**Consultation Response from KC,
Lead Local Flood Authority**

2025/93066 land off, Lockwood Road and Albert Street, Lockwood, Huddersfield, HD1 3QW

Change of use of disused land to form car valeting facility (sui generis use) with welfare and storage unit.

Date Responded: 27th April 2026

Drawn No. 103 Reviewed Title Revision

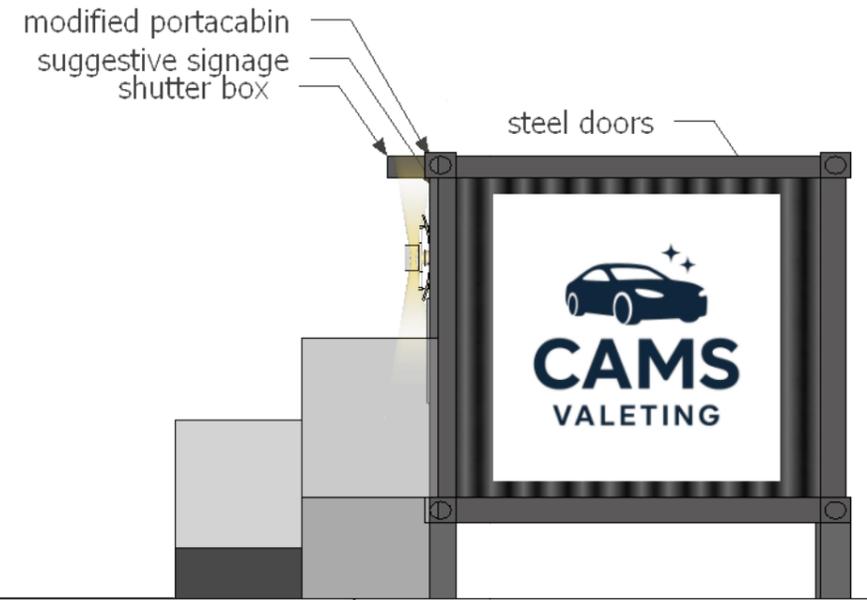
Temporary buildings also need to be anchored to mitigate flood risk in vulnerable areas.

Project No. 2025 Enquiry 70	Project Title proposed site and floor plan	Scale 1:200 @A3 size	Date 31/10/2025
Drawn By	Reviewed By MC		
Drawn No. 101	Reviewed Title		Revision A

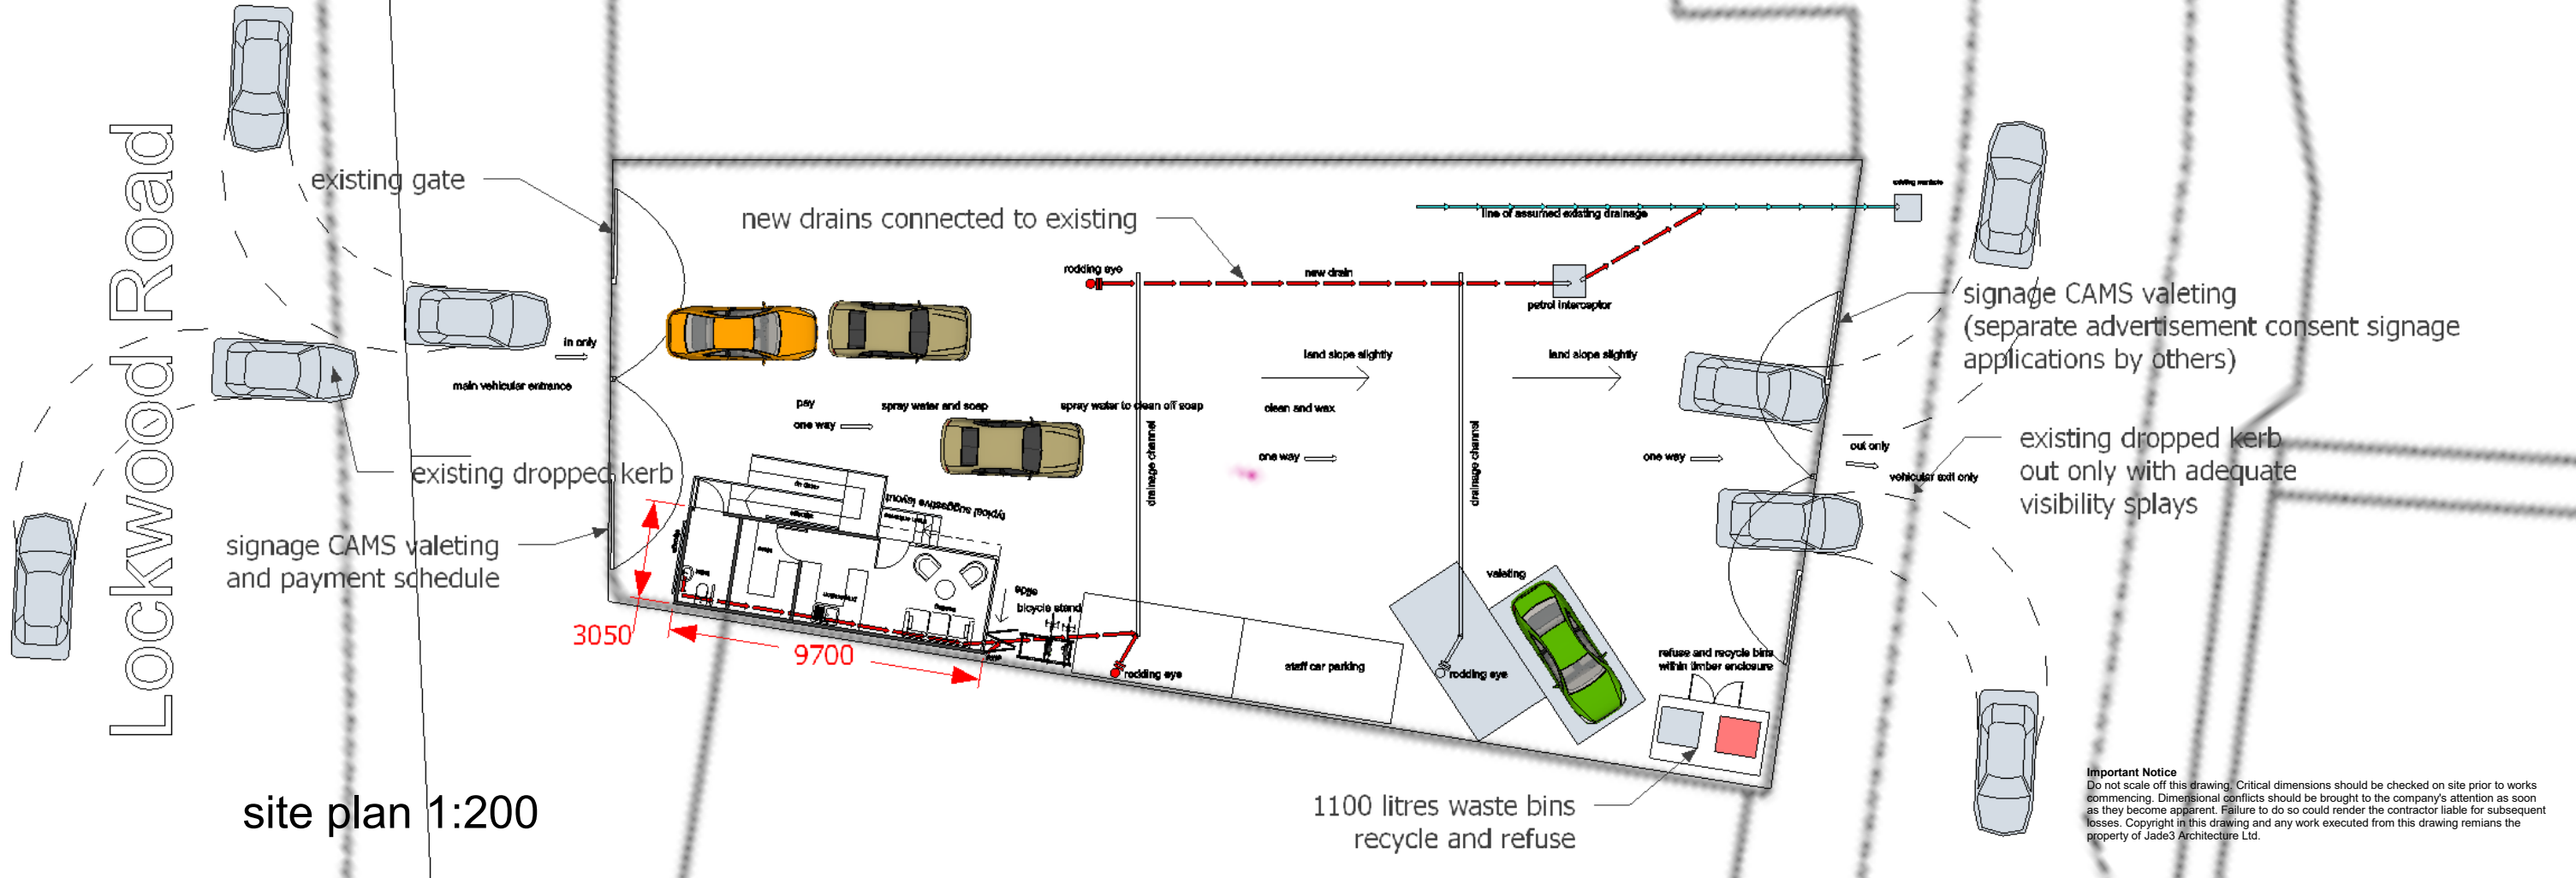
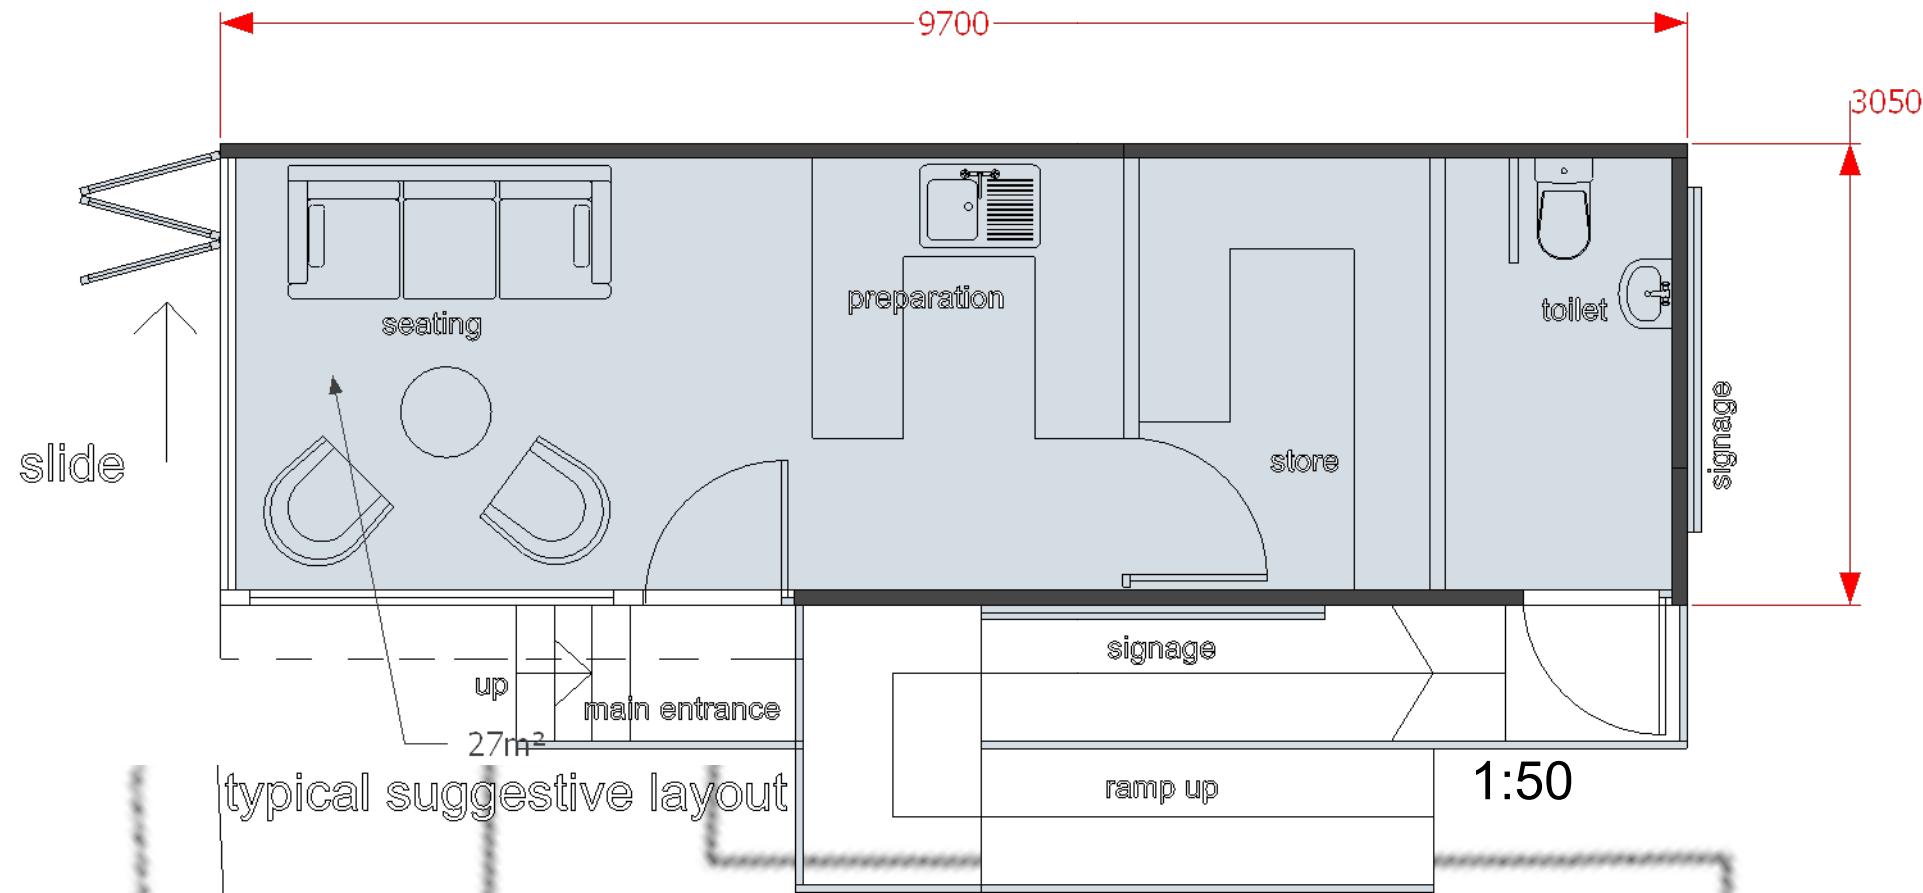
However, as the site is split between flood zone 3 (high risk) and flood zone 2 (medium risk), the opportunity is there to best manage flood risk through the siting of the temporarily buildings to in flood zone 2.

Climate change has not been considered and zone 3 will extend through time. We do feel that a flood risk assessment defining levels of climate change is arguably disproportionate to the size and type of development.

To counter climate change in this scenario would be to position building a far away as reasonably practical from the flood zone 3 boundary.
